Our Case Number: ACP-323873-25
Planning Authority Reference Number:

Re: Kingston Park and Millers Lane - Public Park Urban Realm Project
Kingston Park & Millers Lane, County Galway

Your Ref: JP61.323873
Our Ref: S177AE Kingston Park
(Please quote in all related correspondence)

Re: Section 177AE application by Galway City Council for works to Millers Lane and the proposed Kingston Park in Galway City.

Drawing file: Lighting / 24.2812 P-E103 Millers Lane_Multi Sport Pitch Lighting.pdf

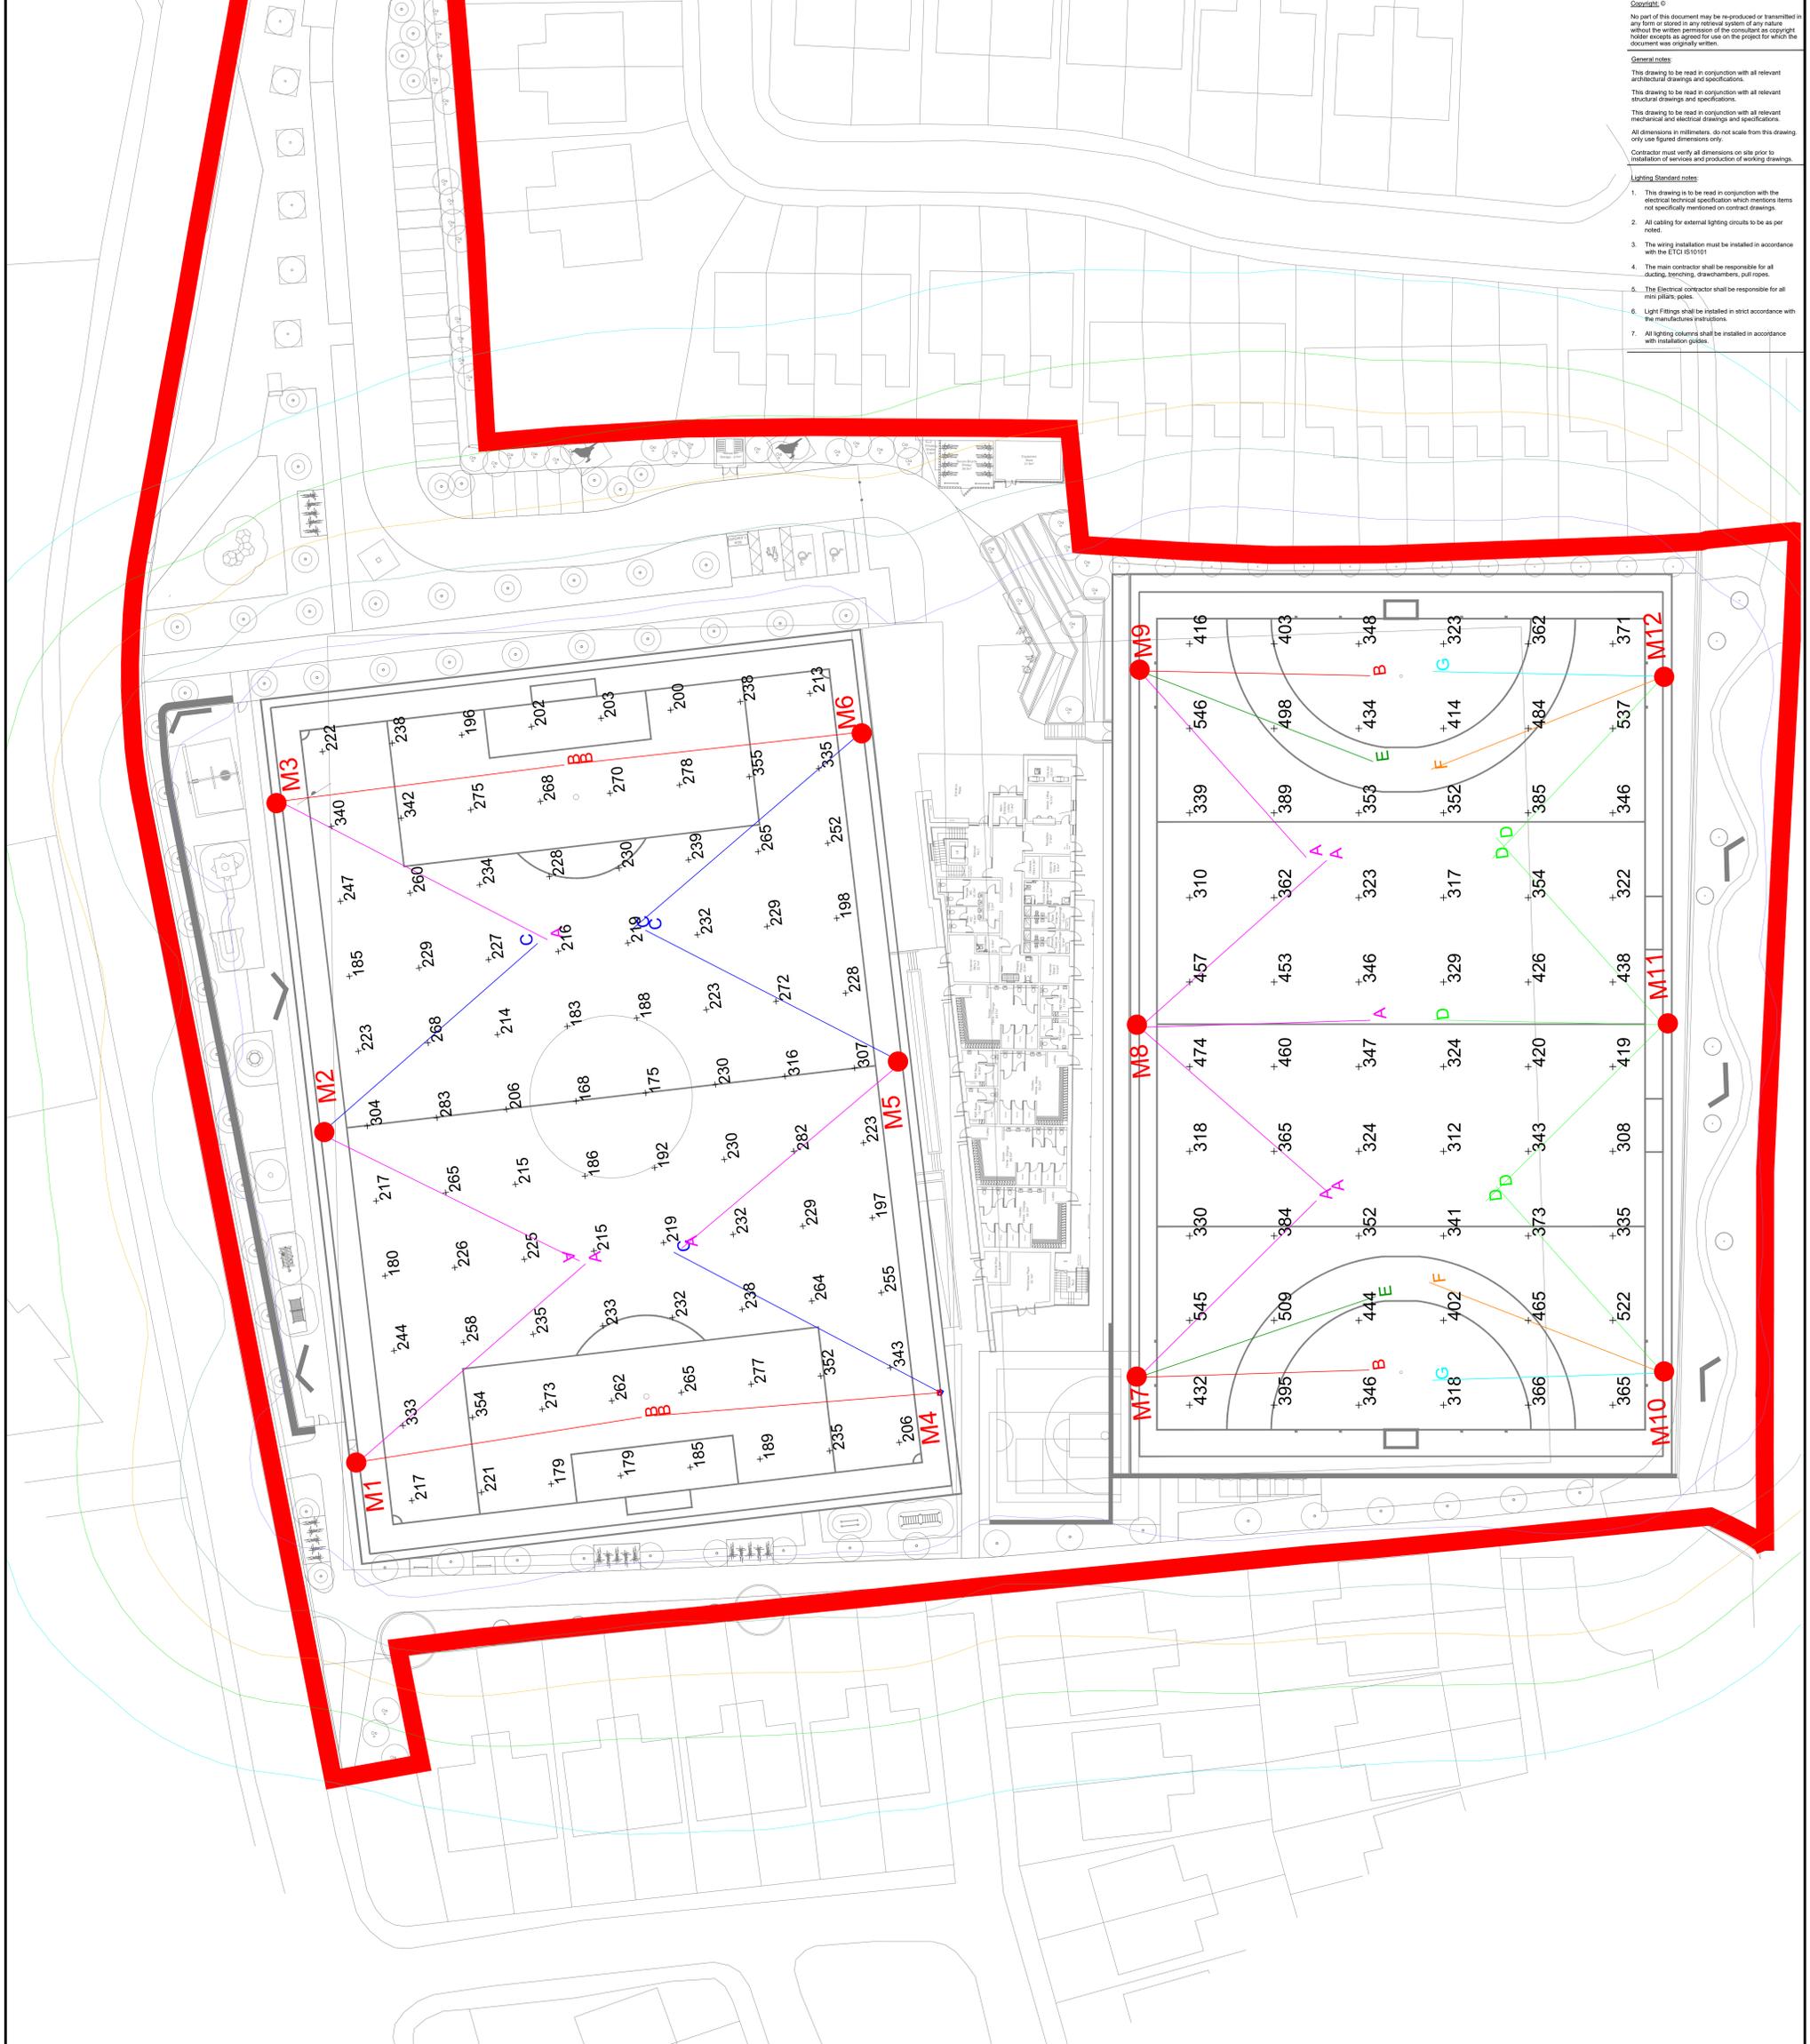
The Department notes that the proposed development includes new permanent public lighting throughout paths, plazas and activity areas. Artificial lighting is a recognised impact pathway for bats and has the potential to disrupt commuting routes, fragment habitat and reduce foraging suitability, particularly for light-sensitive species. The Department notes the Lighting Plan provided in the Bat Report and emphasises the importance of ensuring all recommendations provided are fully implemented. Including luminaire type, lux levels, spectral composition, directional control, spatial extent of illumination and the timing of lights, particularly the sports floodlighting to fully maintain bat connectivity.
